Online Comment

Application H09-0866-17
Location Land North of Bluebell House Dog Drove North Holbeach Drove
Proposal Erection of stable block and use of land for grazing of horses

Name Louise Jennings Historic Environment Officer
Address Witham Park House Waterside South Lincoln LN5 7JA

Drawing Title:			
LAYOUT & ELEVATIONS			
Drawn by UU		Checked by:	Date: 11/9/17
Scale (@ A1): As indicated	Status: PLANNING		
Drawing Number: LE-8245-			Rev D
File Path:			
T:\Dwgs\Job_Dwgs\Langley_8245\Drawings\Langley_8245.rvt

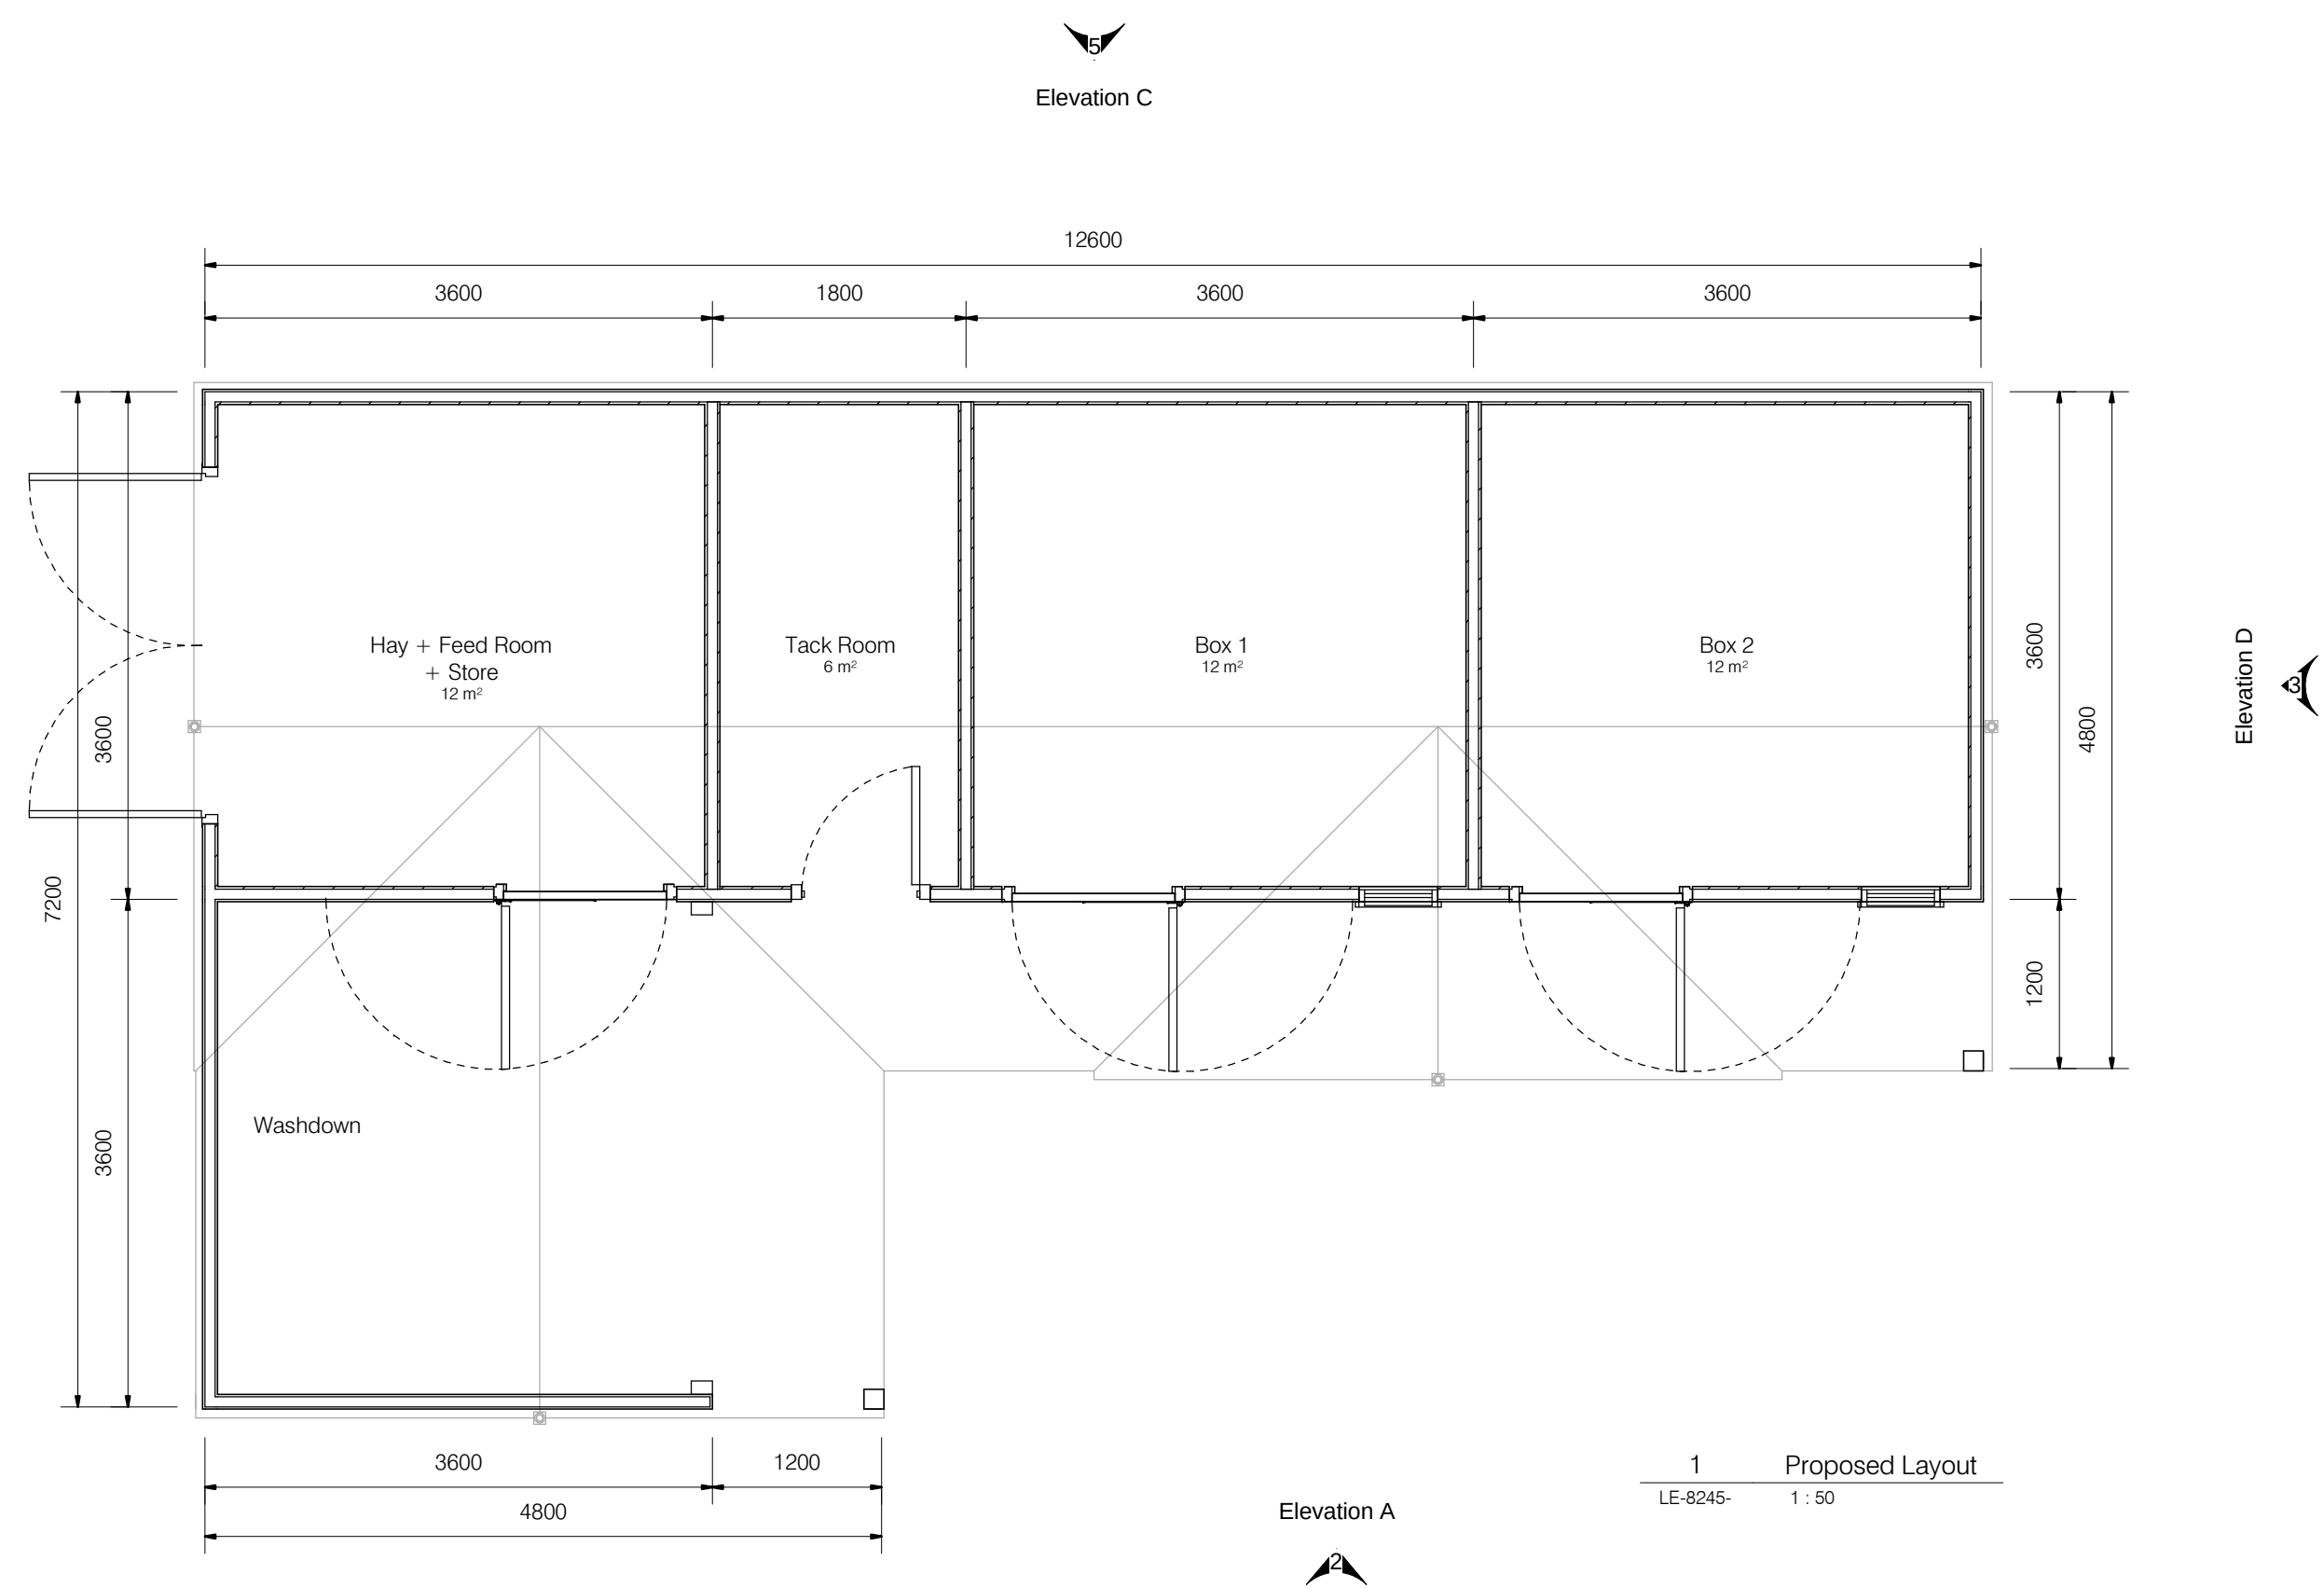
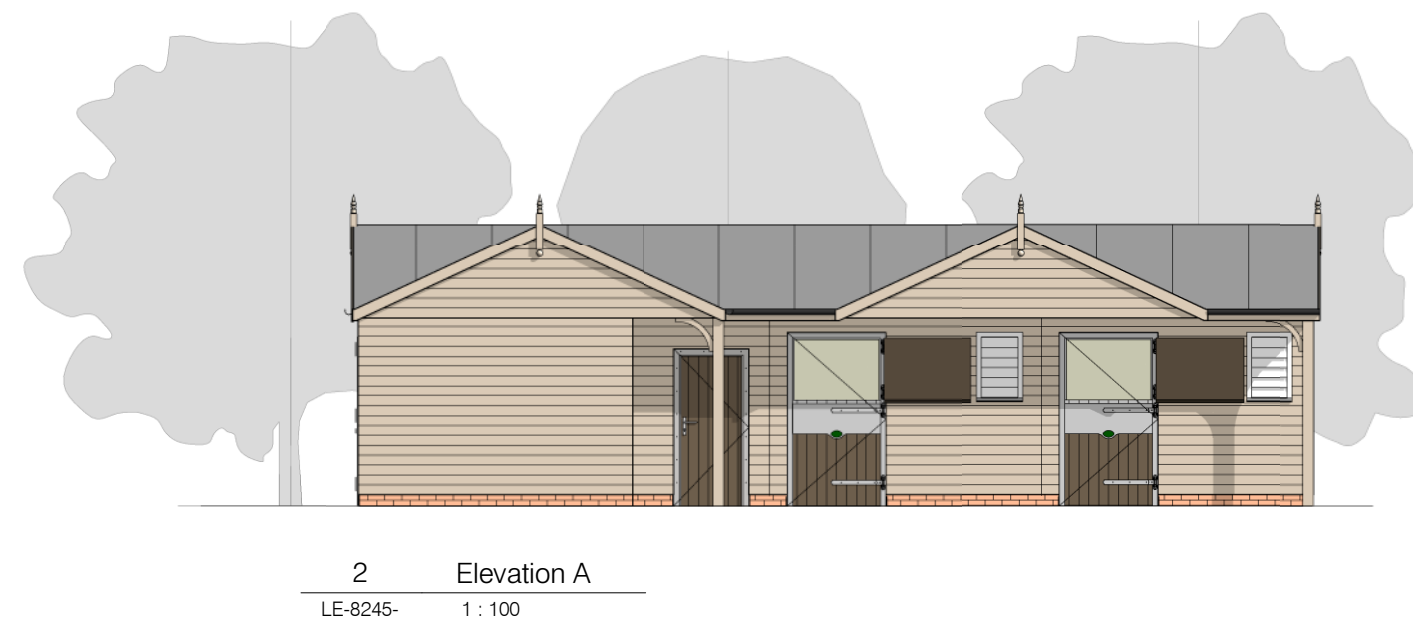
However I am aware that not all stables have significant foundations or necessarily need the site to undergo significant earth works during the development and any associated services. If the applicant can demonstrate that this development will not impact on archaeological horizons I will be happy to reconsider this recommendation.
